REFUSAL OF PERMISSION FOR DEVELOPMENT

Application Number: 2026/62/90571/W

INSTALLATION OF 1 BT STREET HUB, INCORPORATING 2 DIGITAL 75INCH LCD ADVERT SCREENS, AND ASSOCIATED BT PHONE KIOSK REMOVAL (WITHIN A CONSERVATION AREA)

At: PAVEMENT O/S, UTILITA, RAMSDEN STREET, HUDDERSFIELD, HD1 2BQ

Drawing Title
SITE LOCATION MAPS

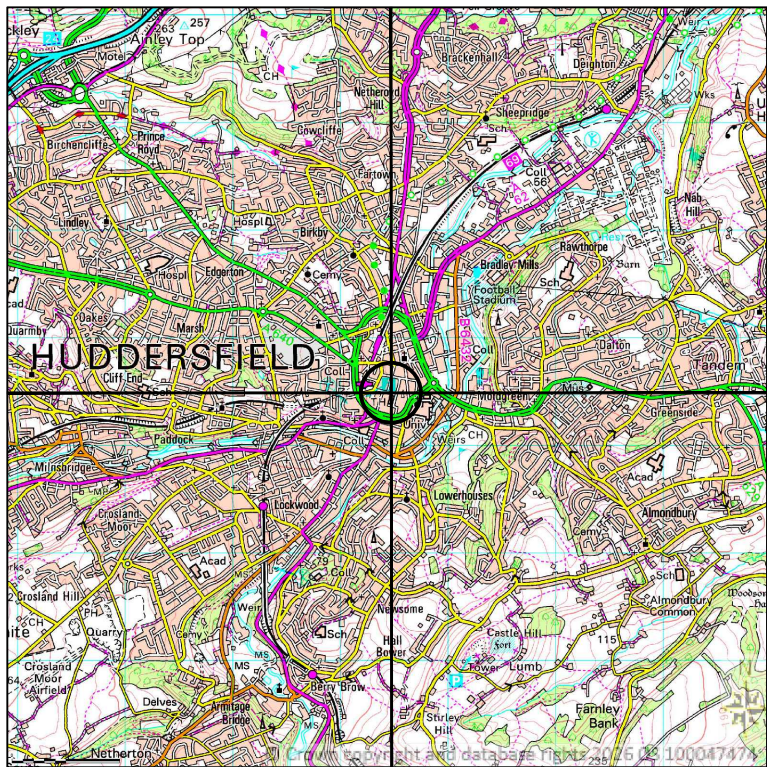
Clarification Note: Submitted plan (ref 001RevA) includes two site location plans at scale 1:1250 which show different sites. This application is assessed on the basis of the top plan (E414438N416461) as this relates to the site with the same address upon the submitted form.

Drg Status PLANNING				
Cell No. & Name HUD-09				
Site Name & Address Pavement o/s Utilita, Ramsden Street, Huddersfield, HD1 2BQ				
Drawing Title EXISTING AND PROPOSED ELEVATIONS				
Scale 1:50		Date 23/02/2026		
Drawn By PTM		Checked By ABH		
Drawing Number 003				Revision A

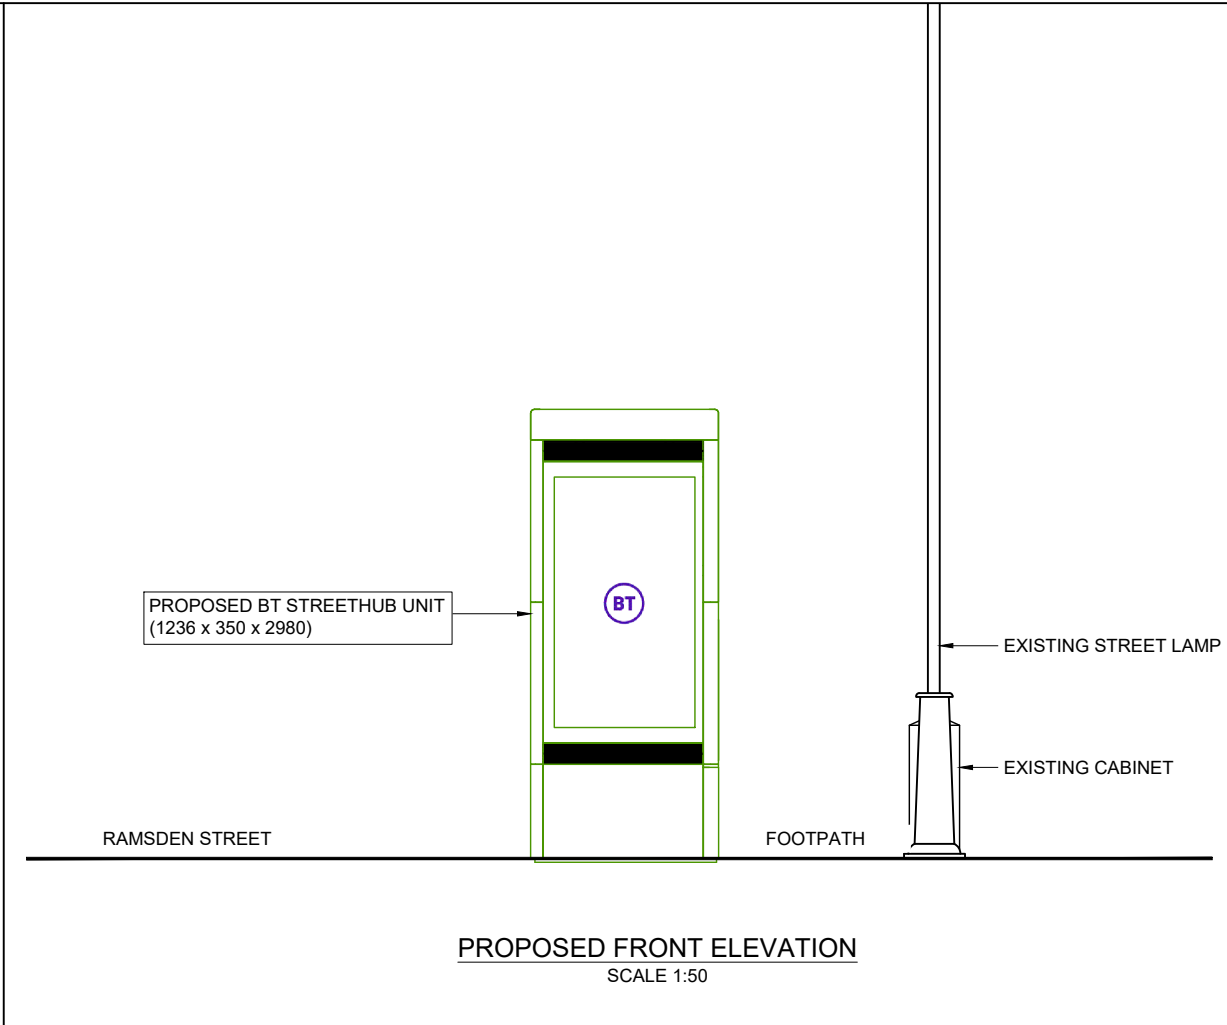
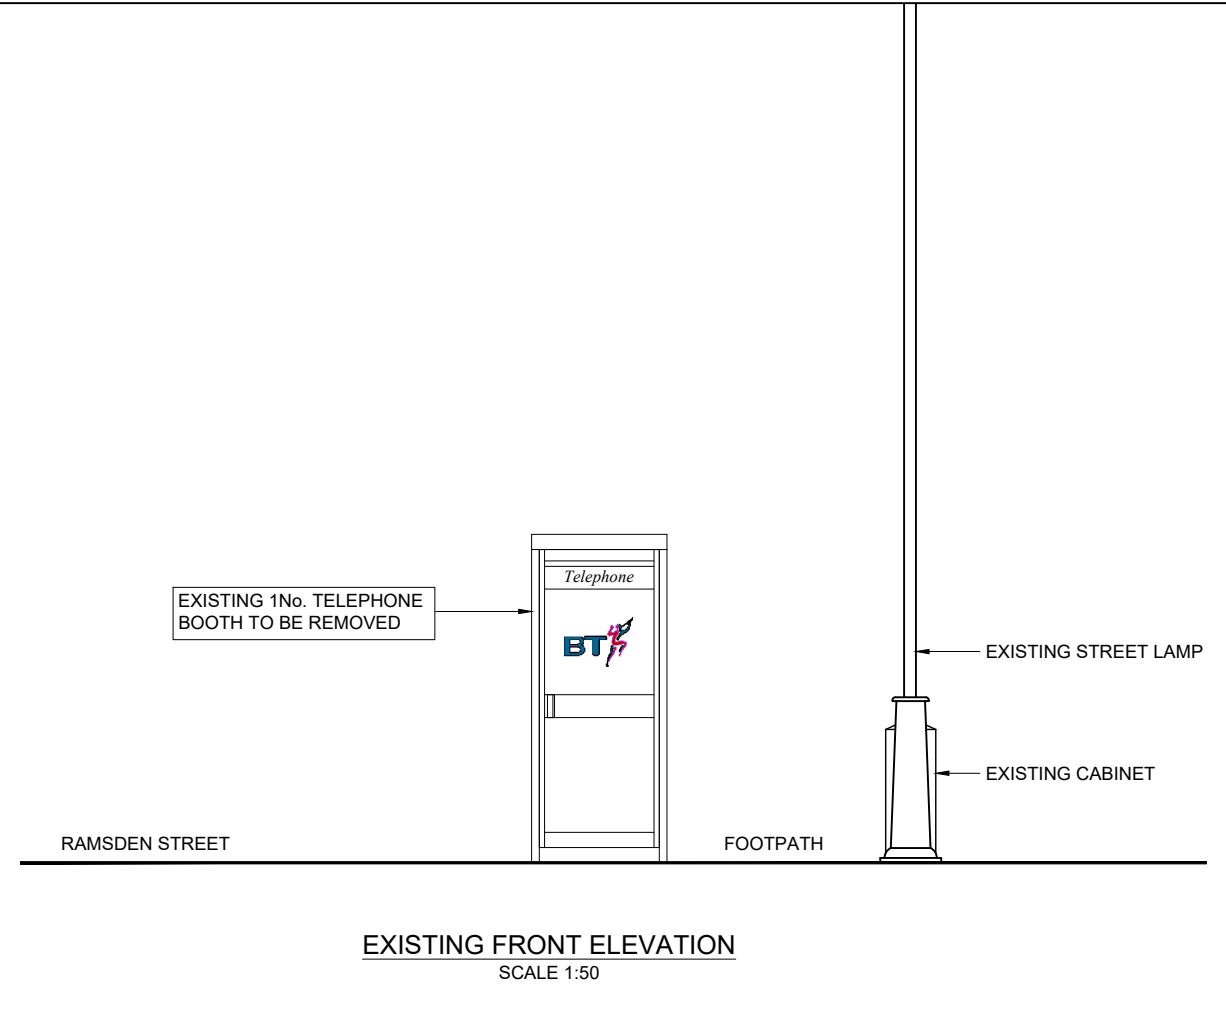
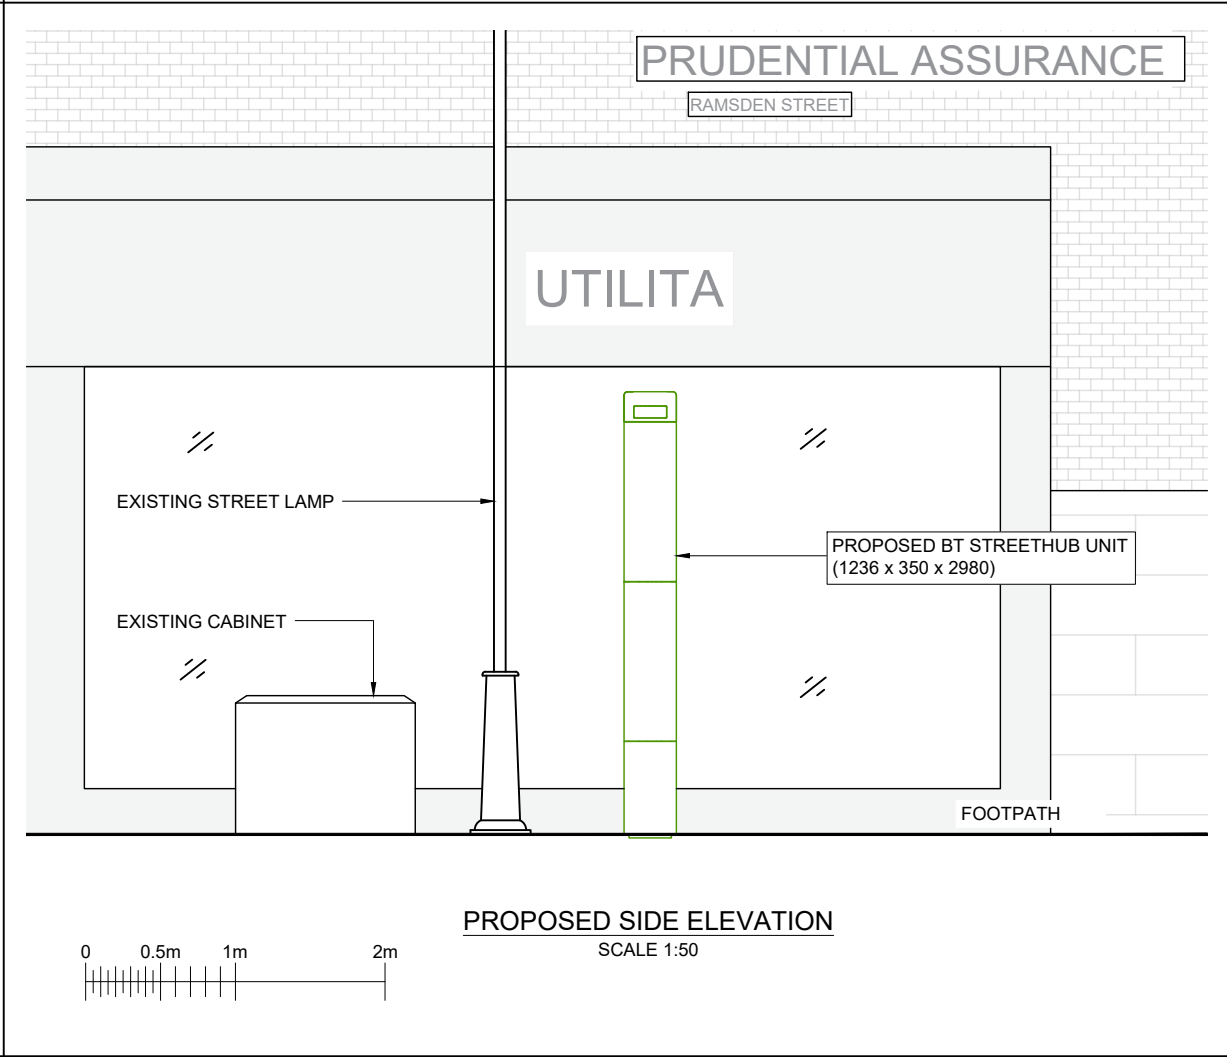
1. The proposed Street Hub would include illuminated screens on both sides. These are an integral part of the development under consideration, as set out in paragraph 2.2 of the Planning Supporting Statement. The proposed Street Hub and digital display screens, owing to their scale, prominent siting, means of illumination and the presence of other similar installations in the immediate vicinity, would be a visually intrusive feature that would cause harm to the visual amenities of the locality and less than substantial harm to the significance of the Huddersfield Town Centre Conservation Area as well as the nearby Grade II listed buildings of 71 New Street, Huddersfield Town Hall, Queensgate Market and 62 New Street and their setting.
